# Comment for planning application 20/01554/Q56

Application Number	<input type="text" value="20/01554/Q56"/>
Location	<input type="text" value="Barn Folly Farm Grange Lane Sibford Ferris OX15 5EY"/>
Proposal	<input type="text" value="Change of use and conversion of 1no agricultural building into 1no self contained dwellinghouse (use class C3) including associated operational development under Part 3 Class Q (a) and (b)"/>
Case Officer	<input type="text" value="George Smith"/>
Organisation	<input type="text"/>
Name	<input type="text" value="John McArthur"/>
Address	<input type="text" value="Folly Farm,Grange Lane,Sibford Ferris,Banbury,OX15 5EY"/>
Type of Comment	<input type="text" value="Objection"/>
Type	<input type="text" value="neighbour"/>
Comments	<input type="text" value="See attached..."/>
Received Date	<input type="text" value="21/07/2020 14:08:58"/>
Attachments	<div>The following files have been uploaded:<ul style="list-style-type: none"><li>• Green Barn - objection.pdf</li></ul></div>

PLANNING APPLICATION – GREEN BARN - 20/01554/Q56  
**Folly Farm, OX15 5EY**

Sketch SK/01 Structural Plan and Section of Former Agricultural Store/Workshop

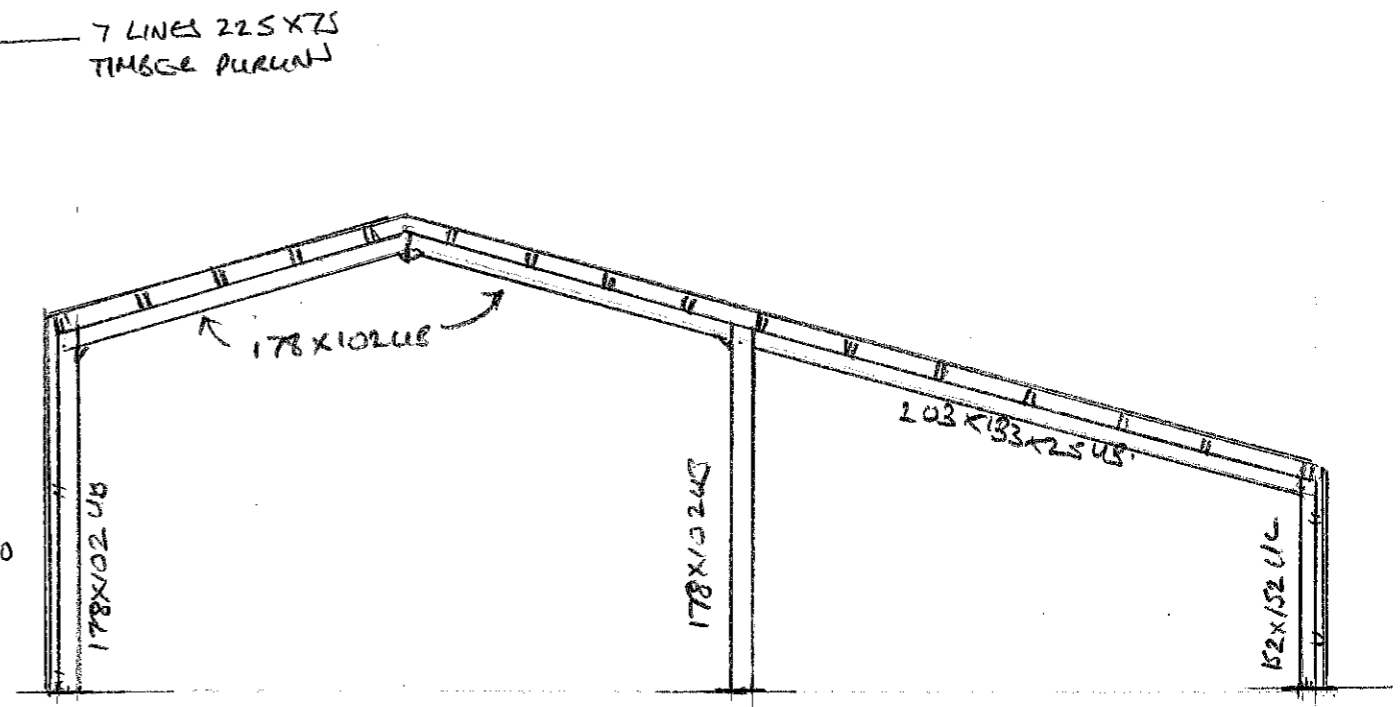
There are anomalies on the Applicants Structural Appraisal.

- A full structural survey was not performed as the roof was not completely assessed, which is quite important as the roof, as stated on the application, is to remain.
- Our farmhouse is about 45m away, but our property boundary is only **16m** away from the proposed building
- There is NO power to the building or in the near vicinity. There was a supply that fed off our supply at Folly Farm to the GREEN barn. The Applicant historically made an annual payment for any units used over the year. **This facility has been removed.**

NORTH ELEVATION

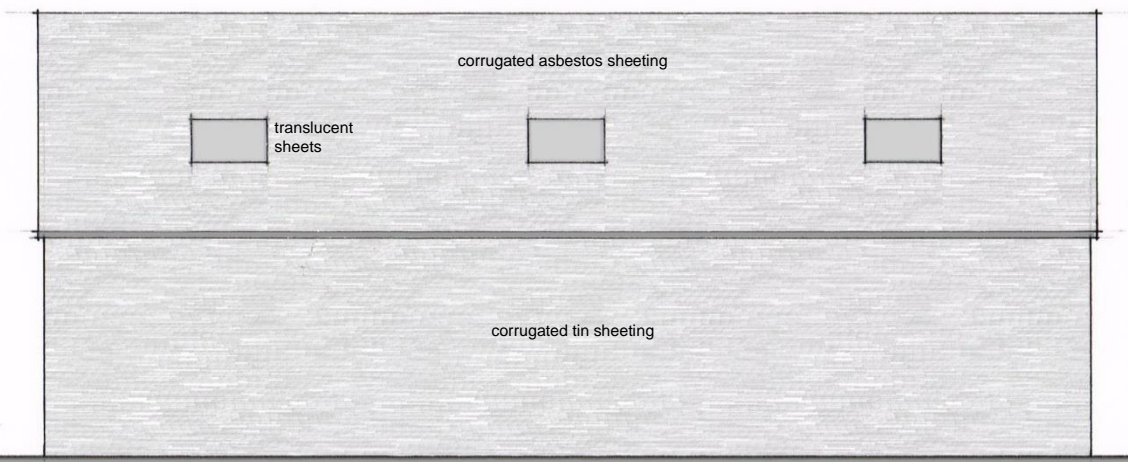
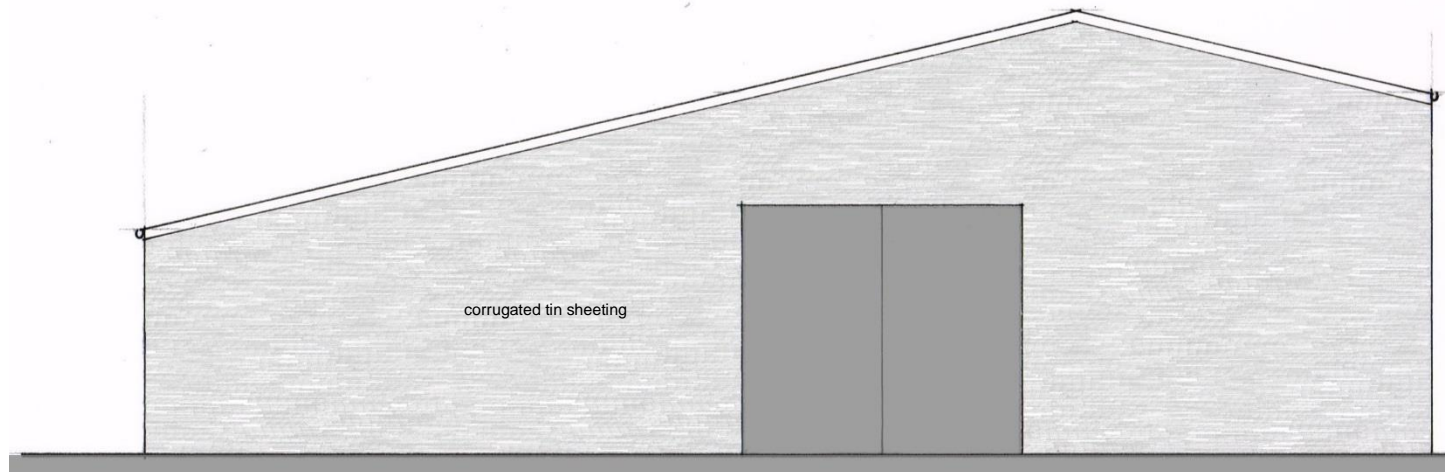
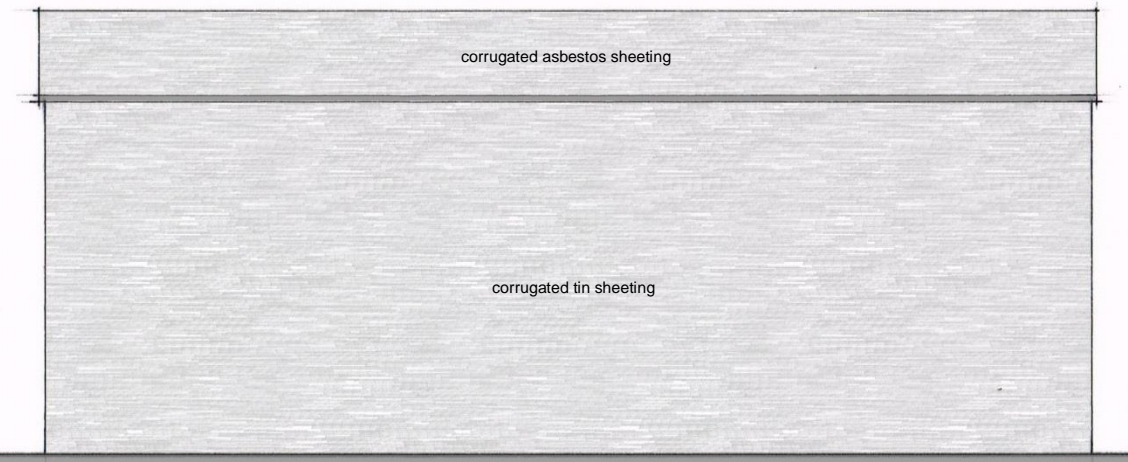
The barn dwelling construction would impact the location visually. The barn is in full sight from the North, South & West. With the site being at one of the highest points in the area, at night, any lights would be highly visible, especially with the North facing elevation of the proposed building being a wall of glass. This would be a prominent, dominating, and distracting sight for people driving along the Sibford Road, into and out of the village.
